From: Amanda Scholes on behalf of Planning.Responses
Sent: 12 March 2018 08:29
To: Planning Scanning
Subject: FW: AL/5/18/RES Woodgate Farm (revised parking layout)

2nd Highways Consultation Response

From: Ian Hayward [<mailto:ian.hayward@westsussex.gov.uk>]
Sent: 09 March 2018 13:27
To: Simon Davis
Subject: RE: AL/5/18/RES Woodgate Farm (revised parking layout)

job no: 17 drawing no: (01)101 revision: P5

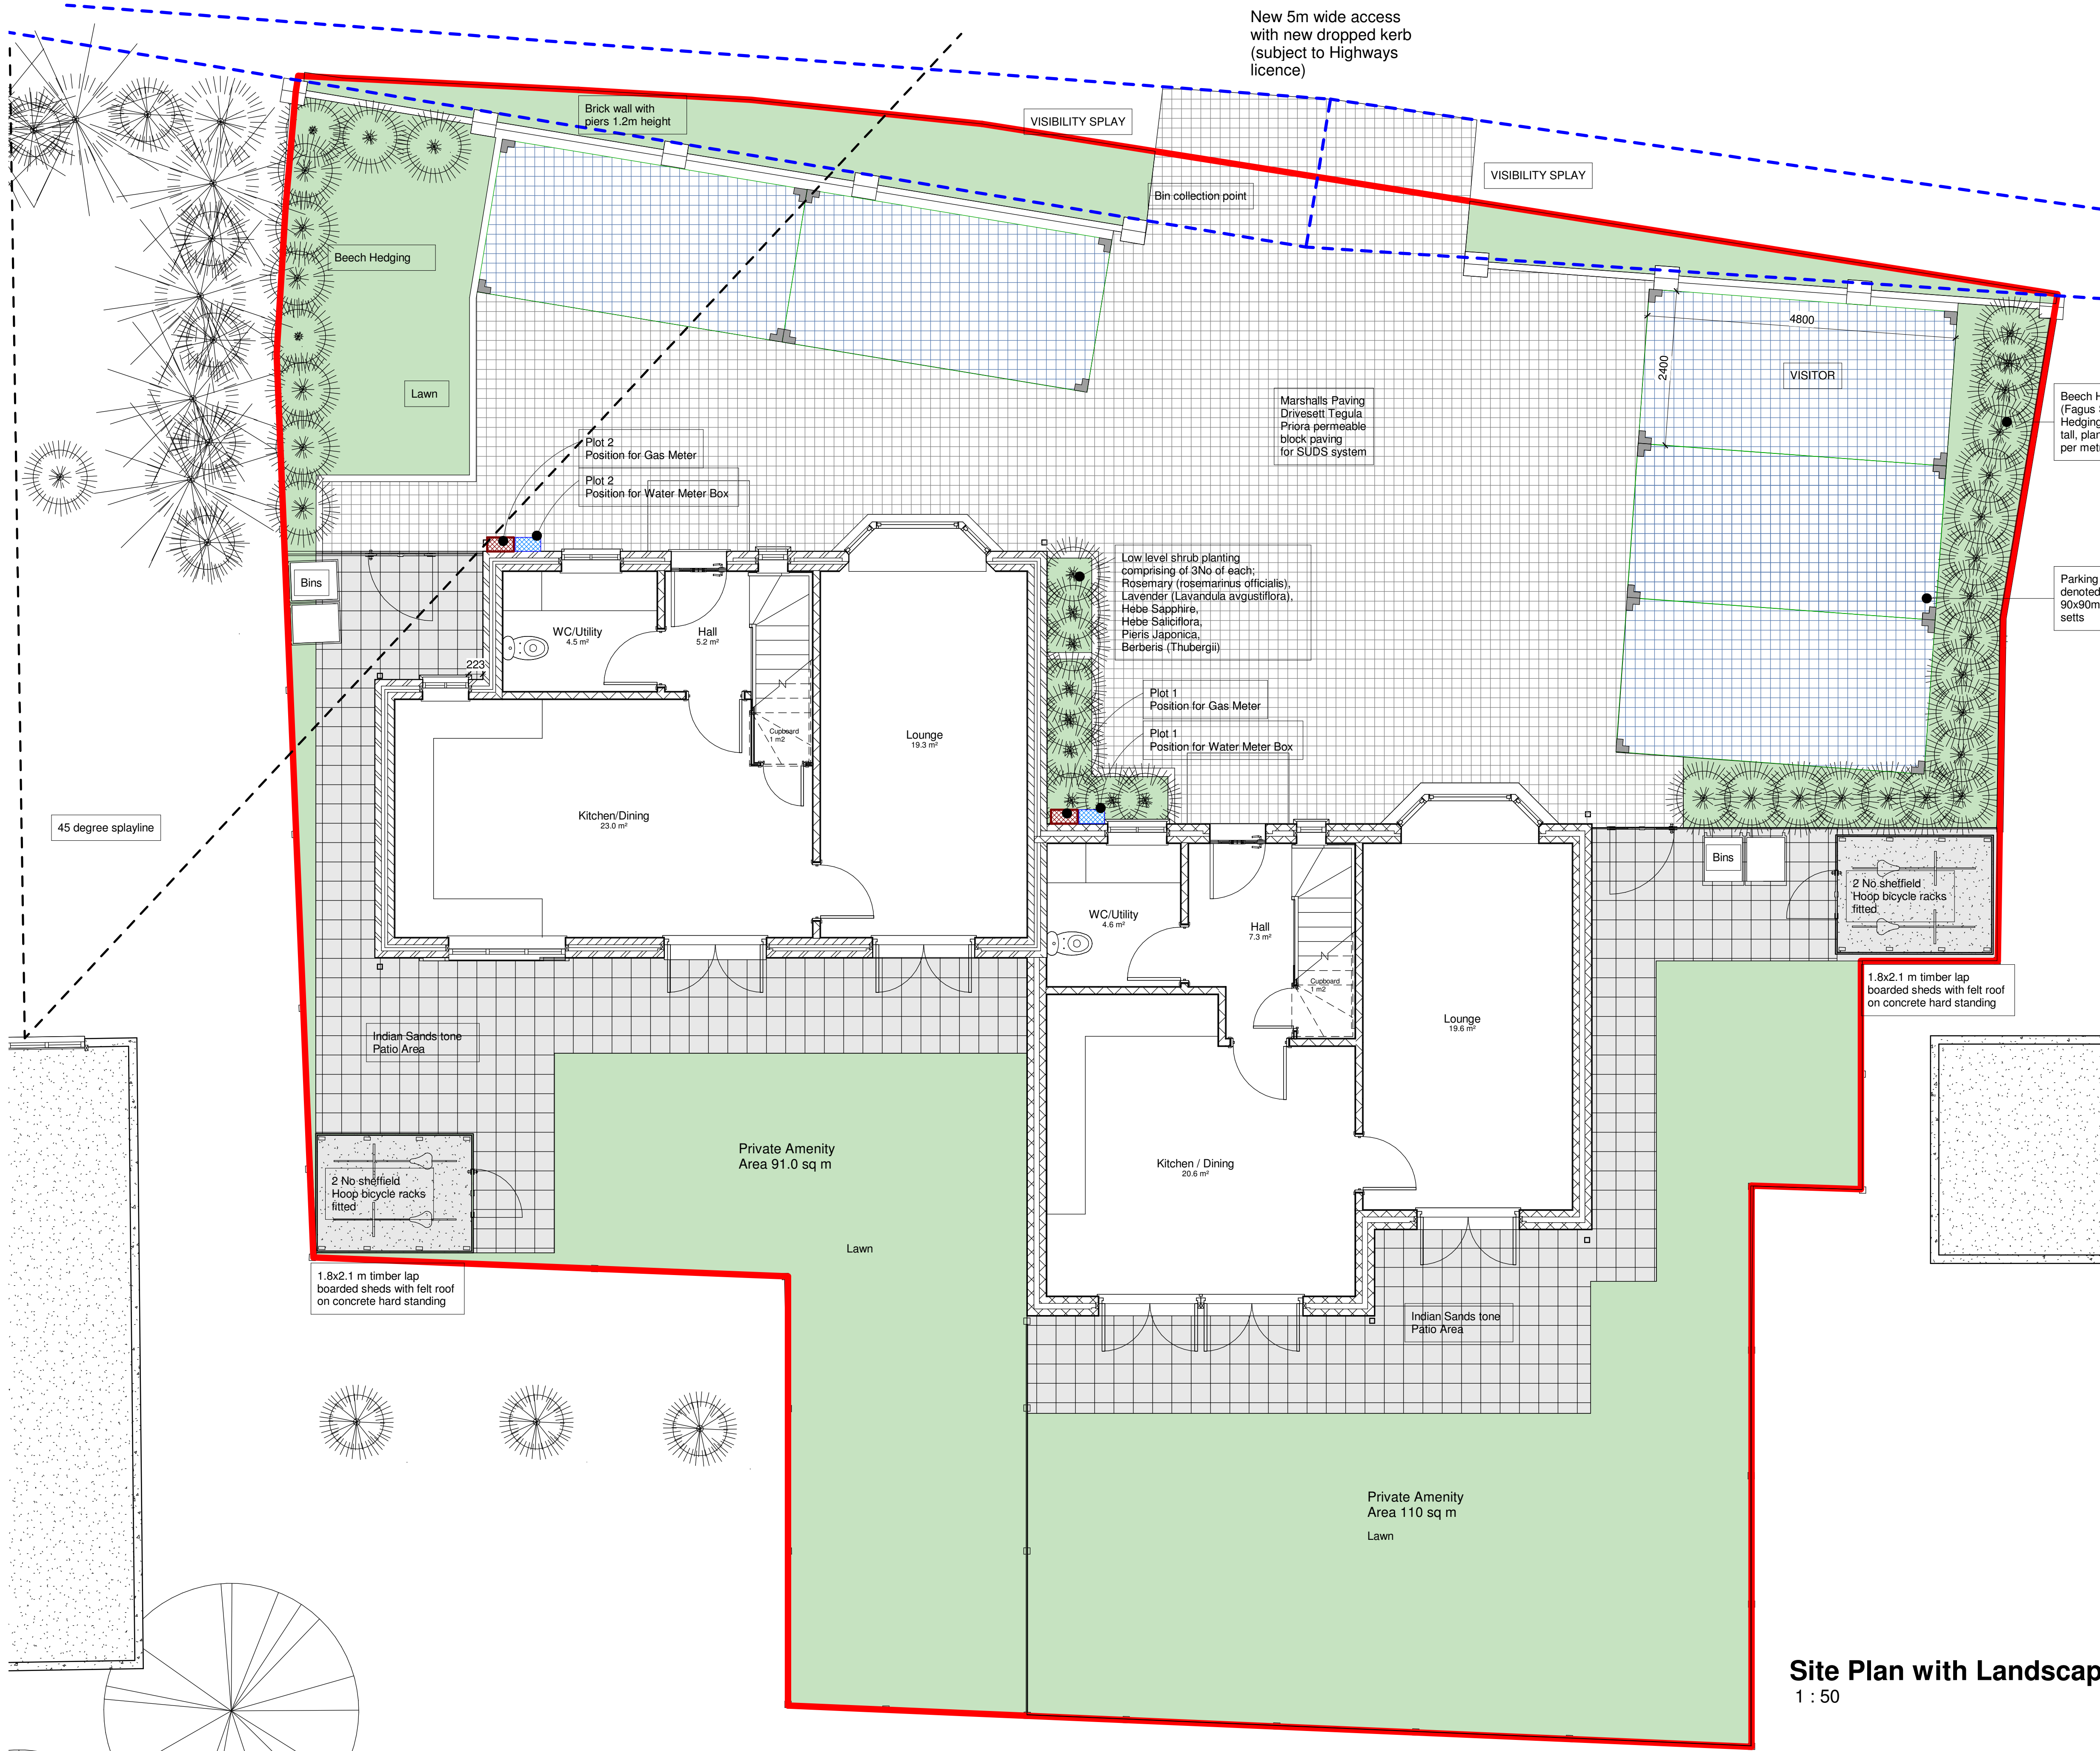
I can confirm that after review of the latest plans, namely (01)101 P4, the parking layout and allocation (2 allocated per dwelling and 1 unallocated visitor space) would be considered acceptable to meet the needs of the development.

The demonstrated cycle store sheds on plan (01)101 P4 would also be considered acceptable.

No part of the development shall be first occupied until covered and secure cycle parking spaces have been provided in accordance with the approved plans..

No part of the development shall be first occupied until the vehicle parking and turning spaces have been constructed in accordance with the approved plans. These spaces shall thereafter be retained for their designated use.
